City of Albuquerque

March 23, 1984

RE: GRADING & DRAINAGE PLAN FOR PARKING LOT FOR NAPA
ALBUQUERQUE FACILITY (J14-D40) RECEIVED MARCH 6, 1984

GRADING & DRAINAGE PLAN

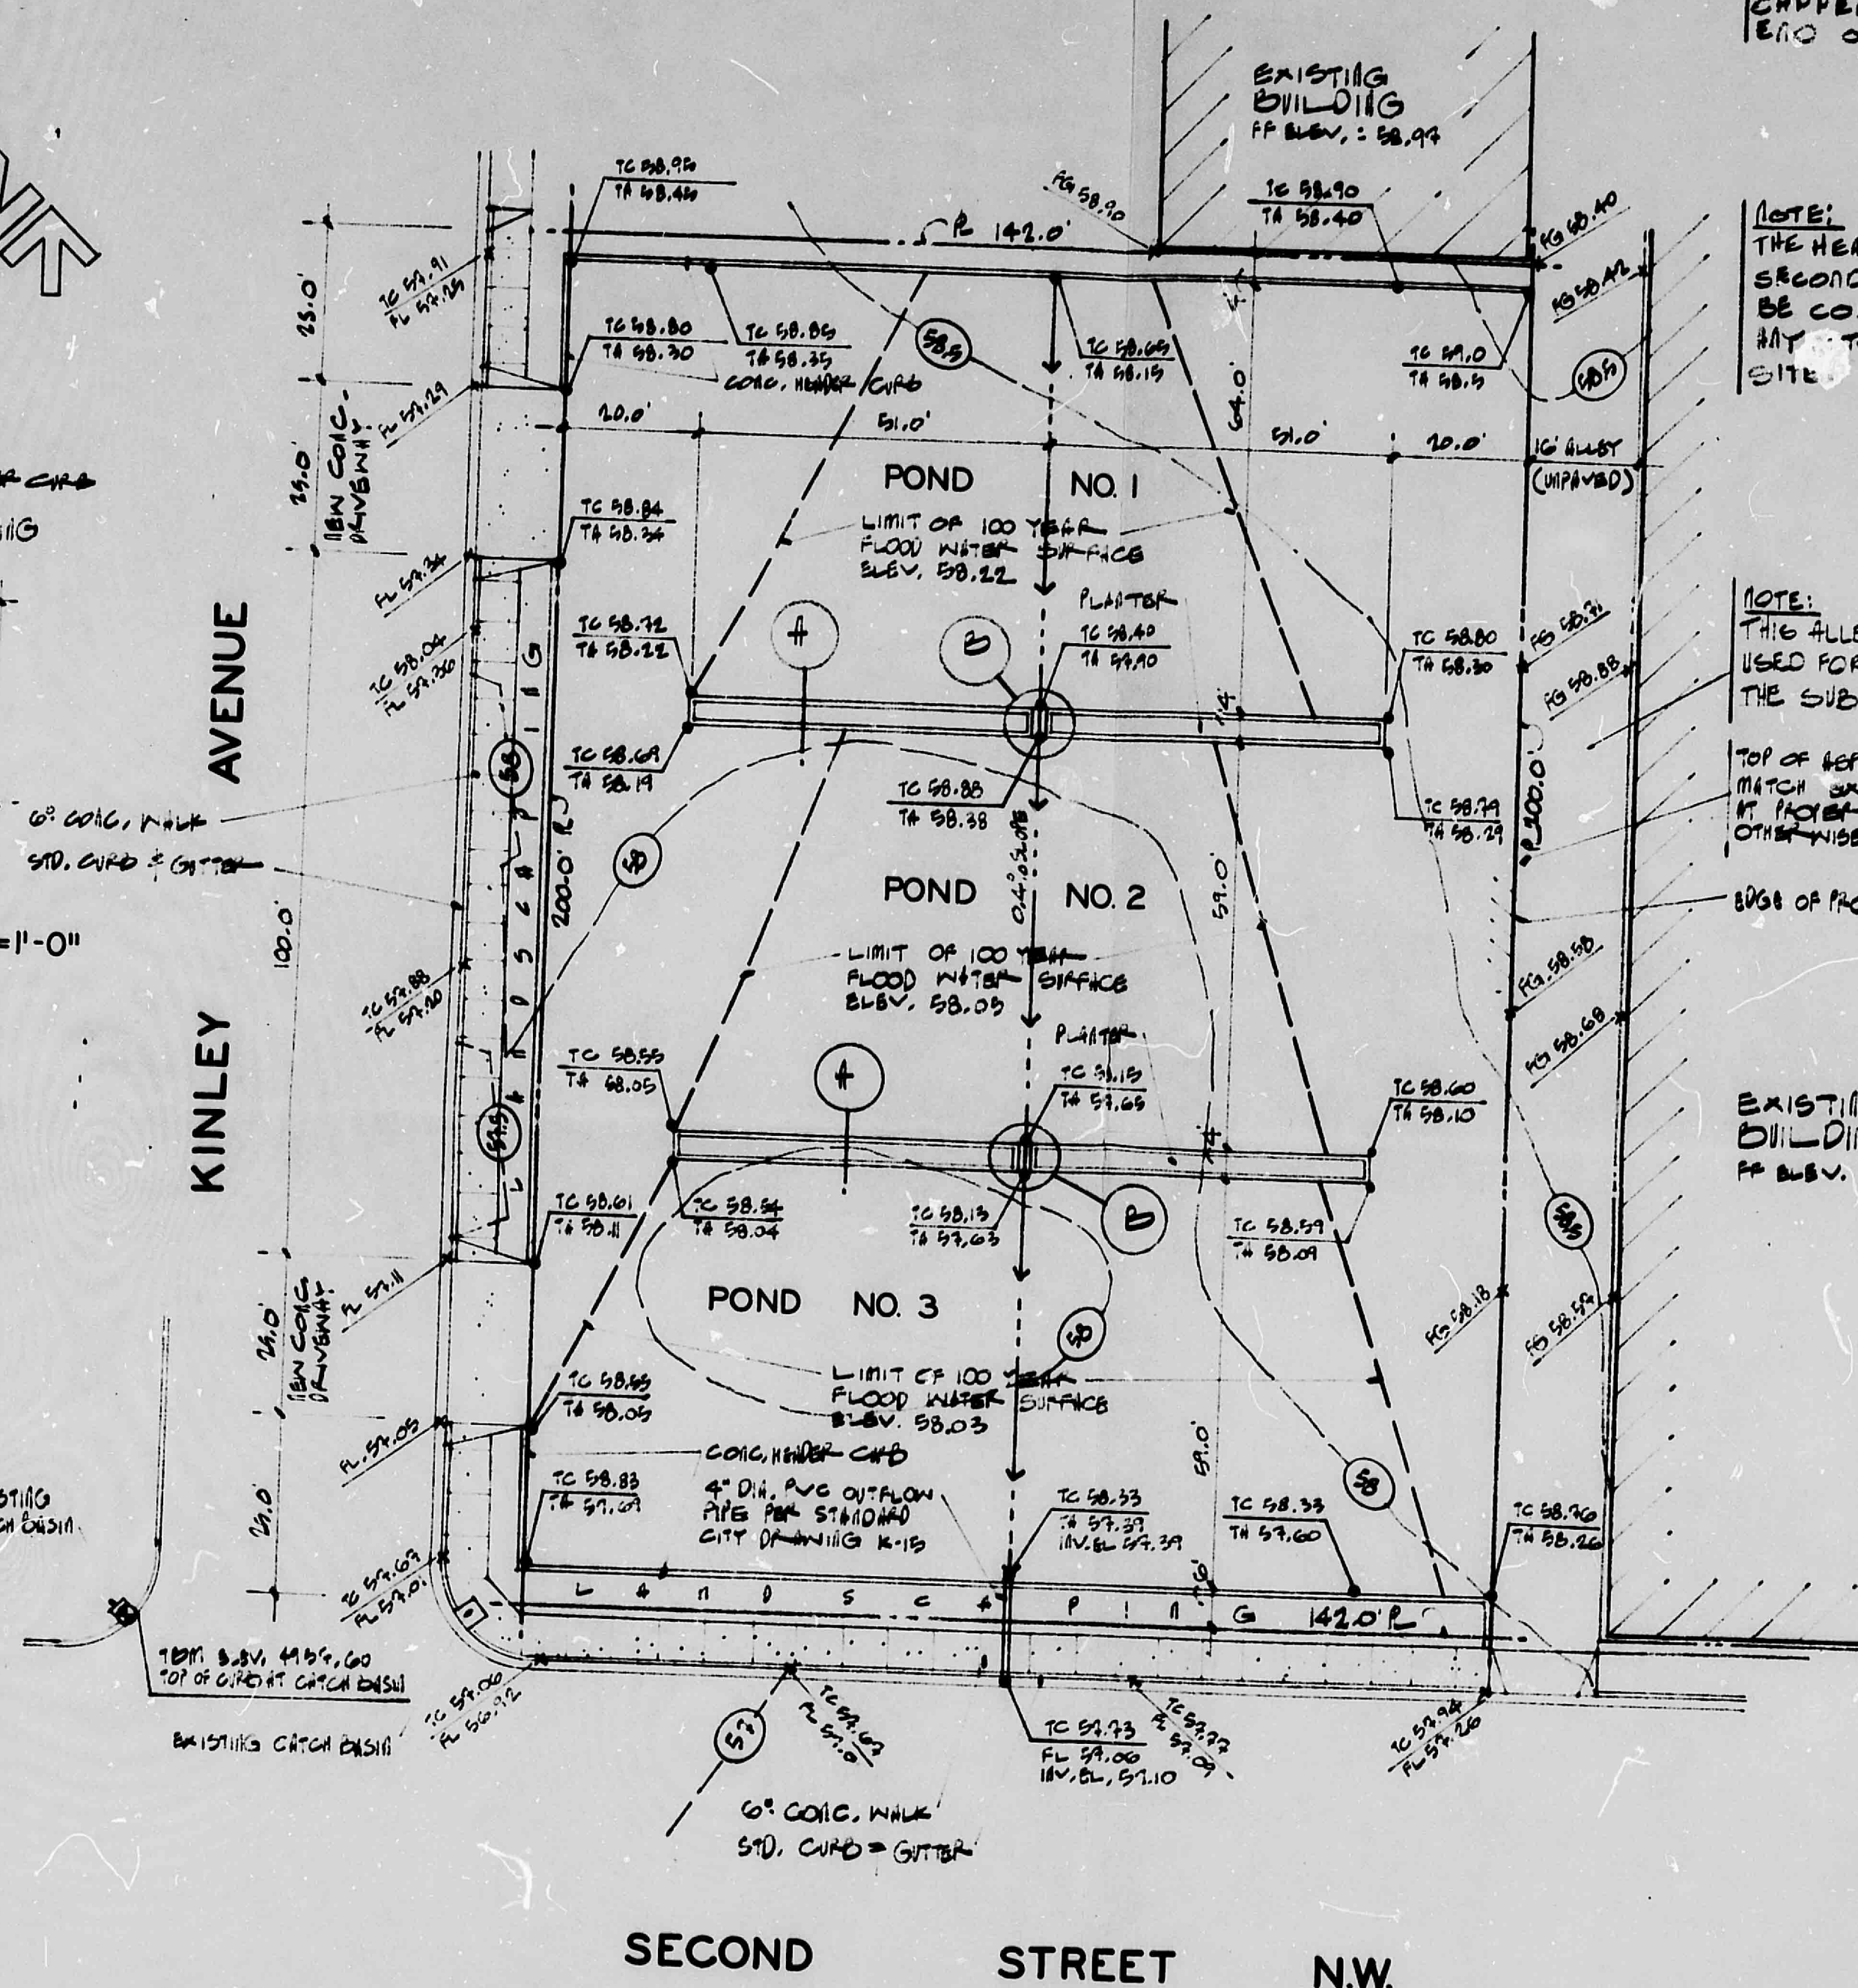
- ✓ 1. The off-site flows have not been addressed.
- ✓ 2. What is the discharge rate from the site and how will it be achieved? The plan indicates a 4" sidewalk culvert but, there is no further mentioning of it. What is the head on this pipe? I cannot verify if it will work. Where are the emergency spillways? What do they look like?
3. The plan indicates that the site is adjacent to an alley. Approved alley grades are required.
4. The plan should have the legal description on it or the current plat should be provided.
5. An Erosion Control Plan should be provided for the period of construction.
